Dongwha Timbers

Bombala Sawmill Modification to Consent Submissions Response

December 2014

Figure 1

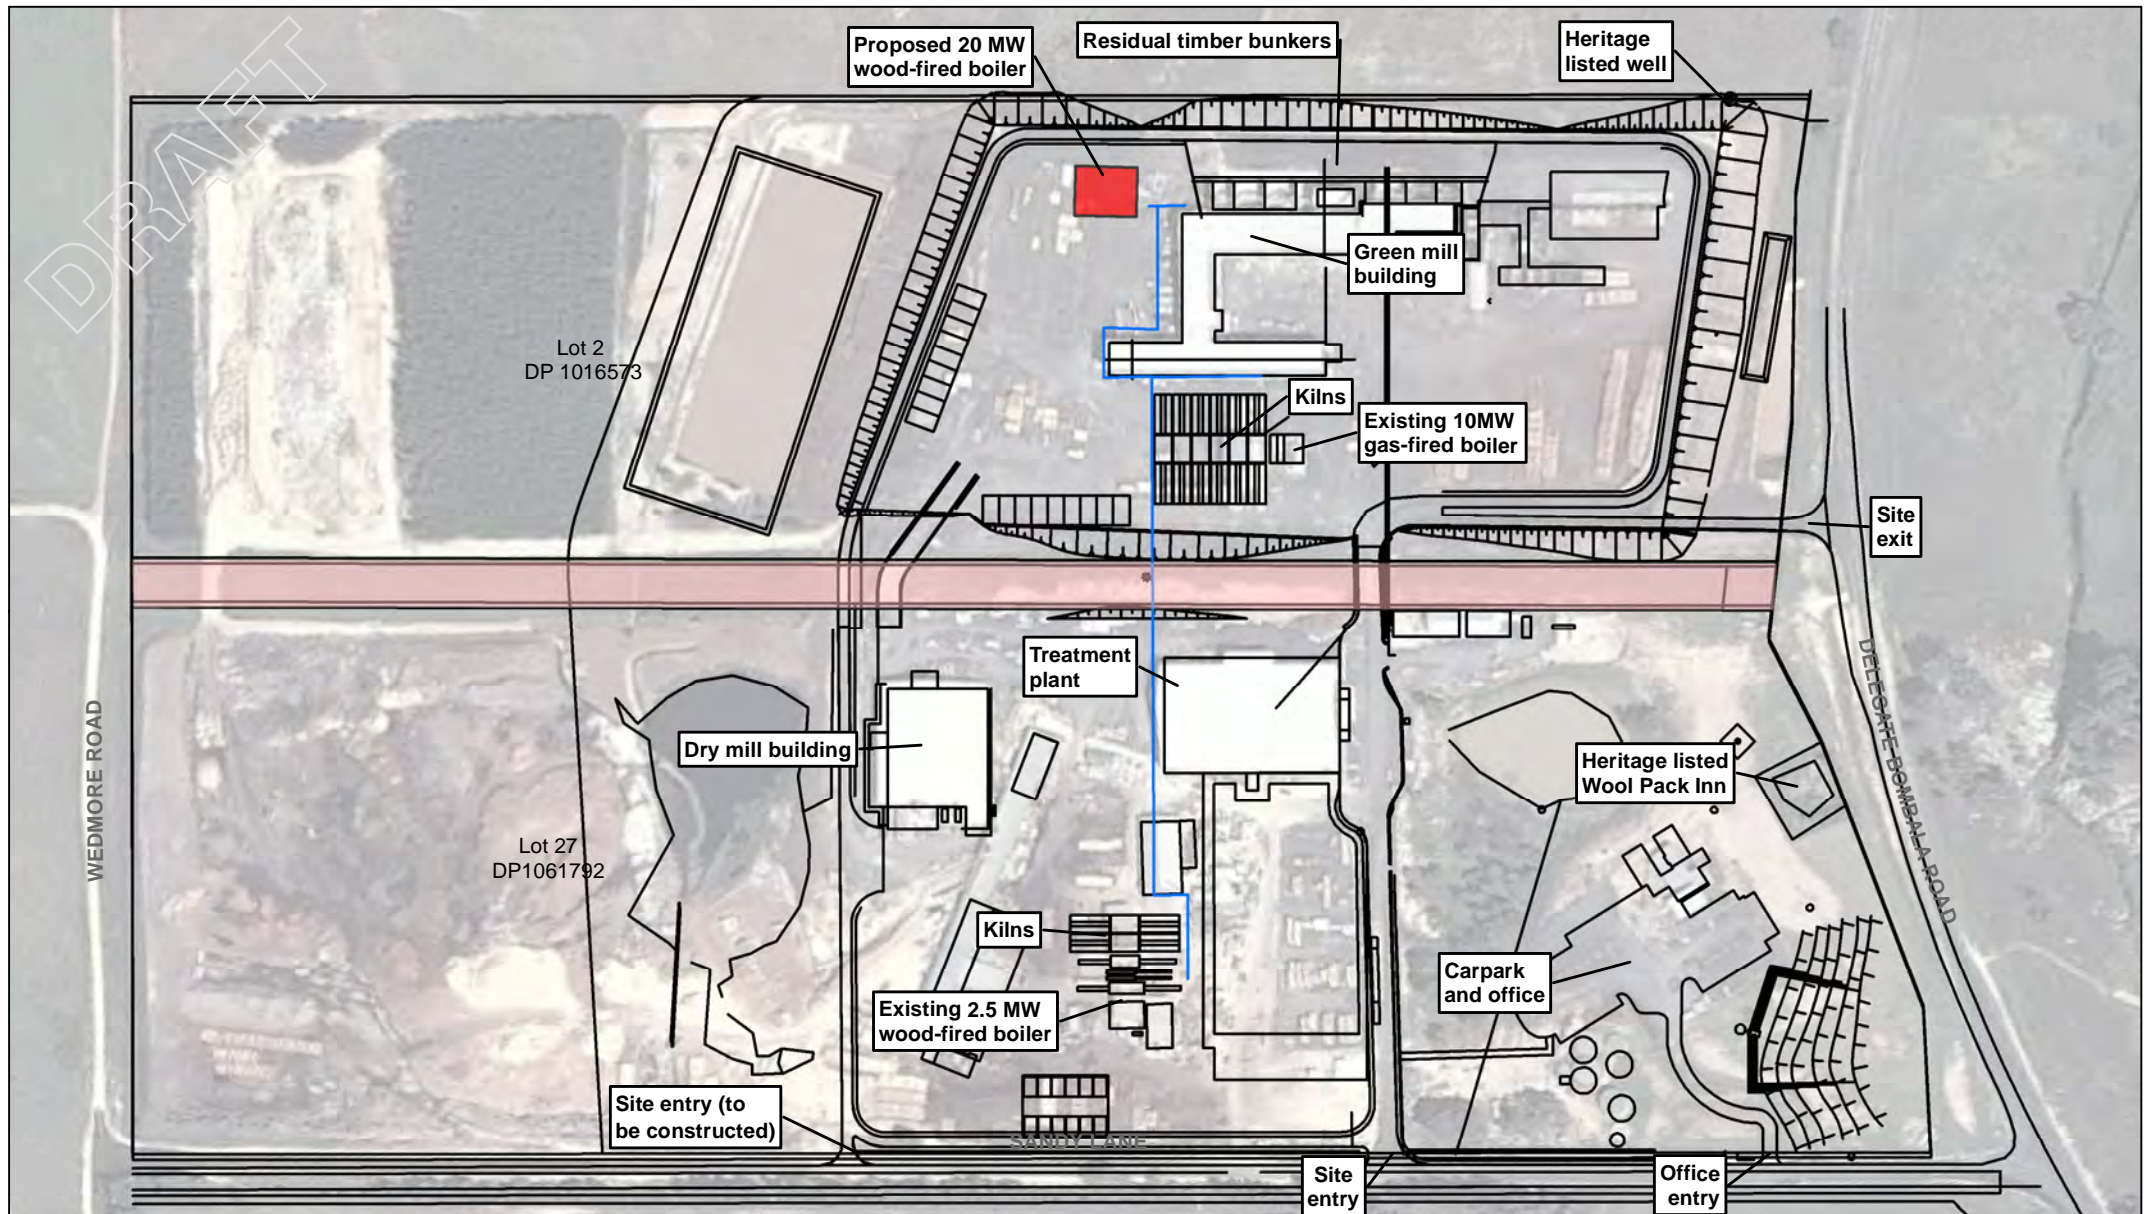
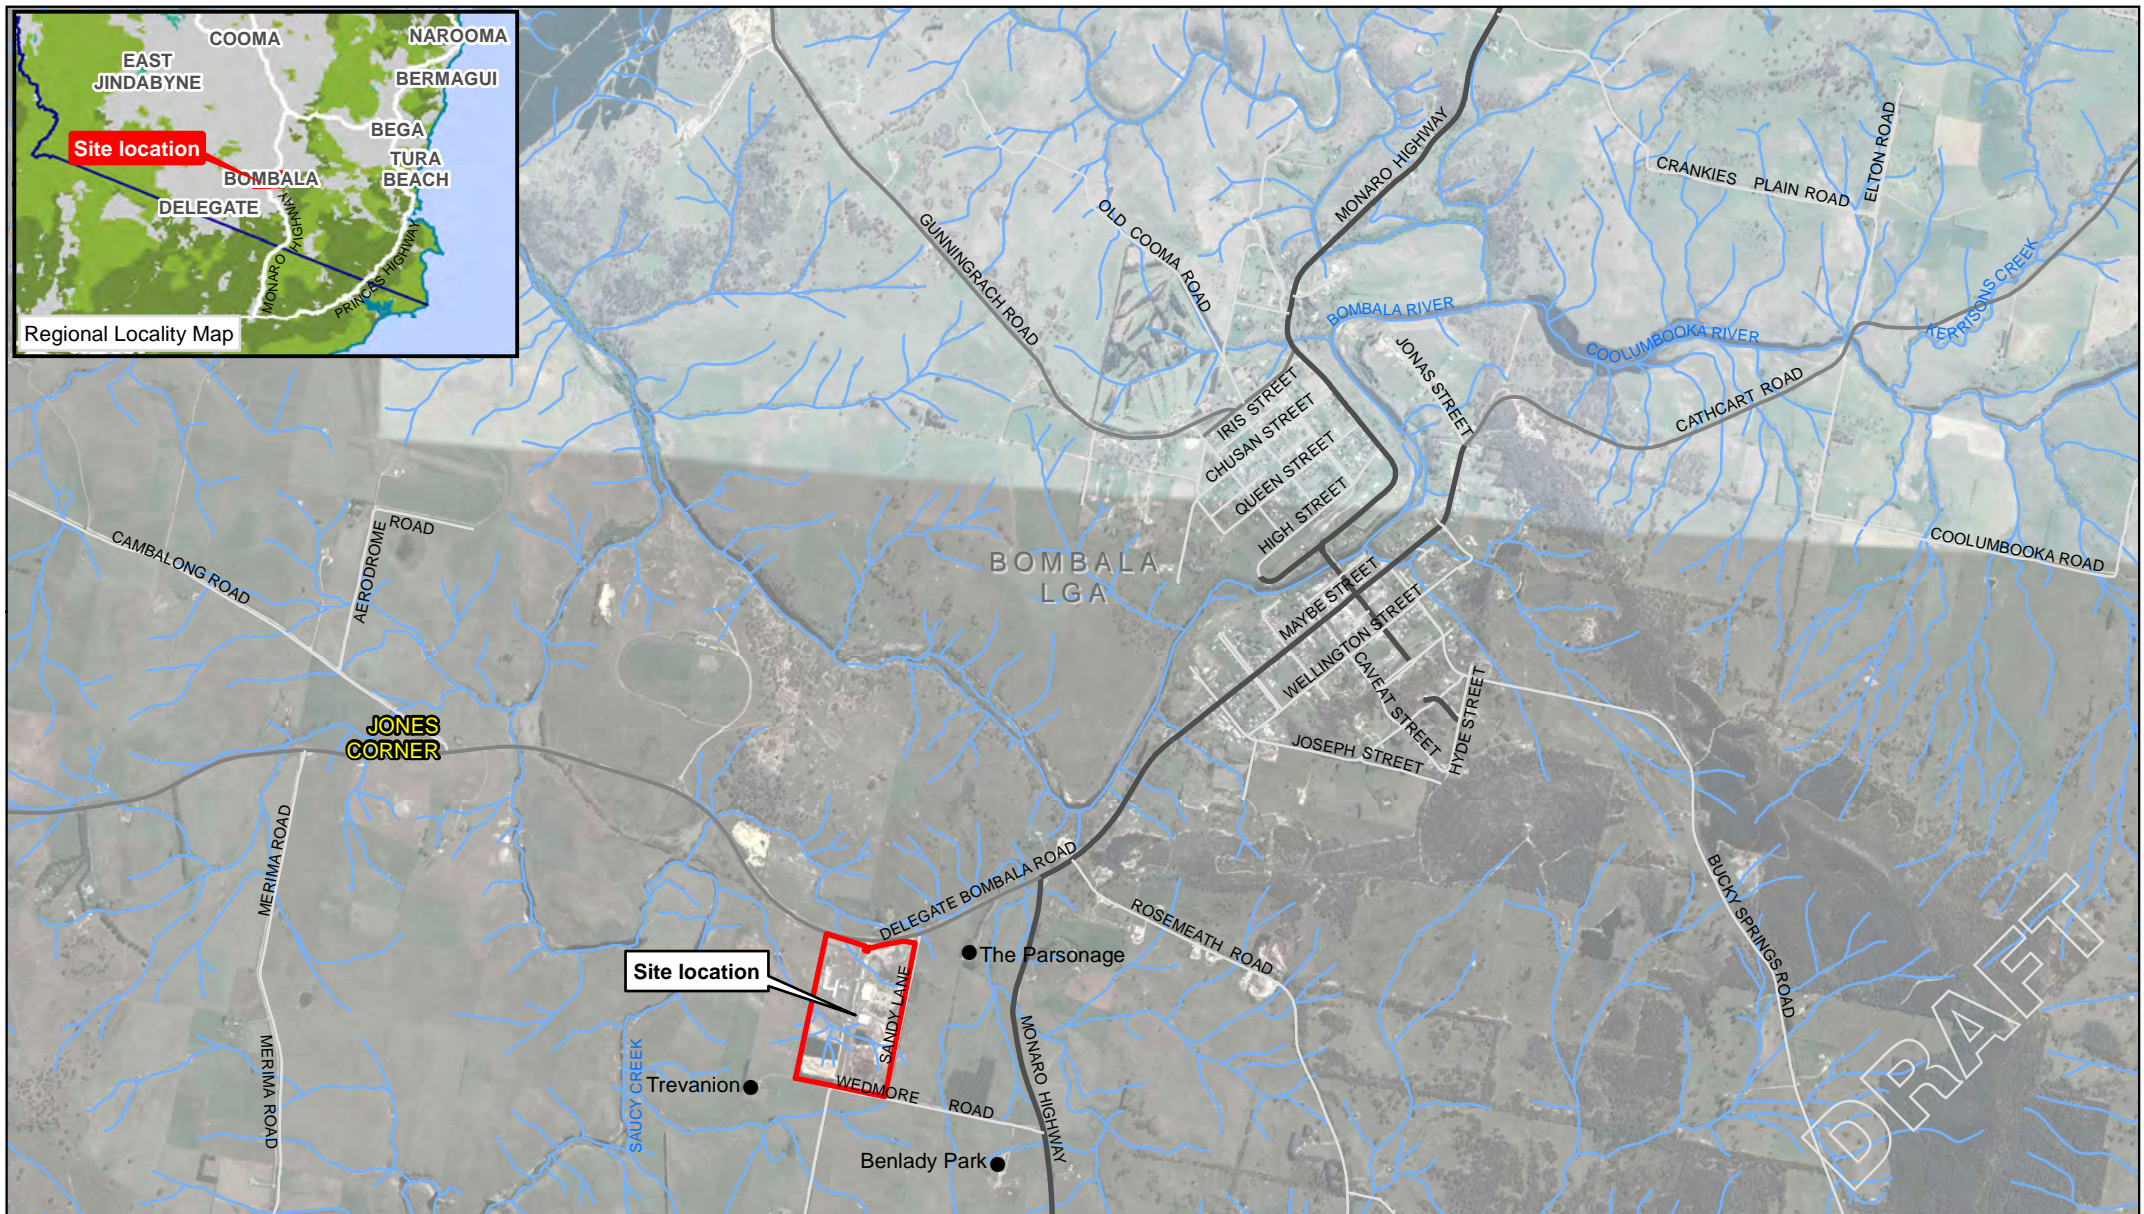
The EA indicated that the footprint of the boiler would be approximately 25 metres by 25 metres with a height of approximately 10 metres. The detailed site layouts indicate an expanded boiler footprint of approximately 90 metres by 30 metres with a filter height of 15 metres and total stack height of 30 metres as shown on a revised Figure 2.1.

The detailed layout includes a dedicated woodchip and residual timber bunker and conveyor to service the boiler together with other ancillary equipment including the control room, water softener and water tanks as shown on the layout diagrams included in Appendix A.
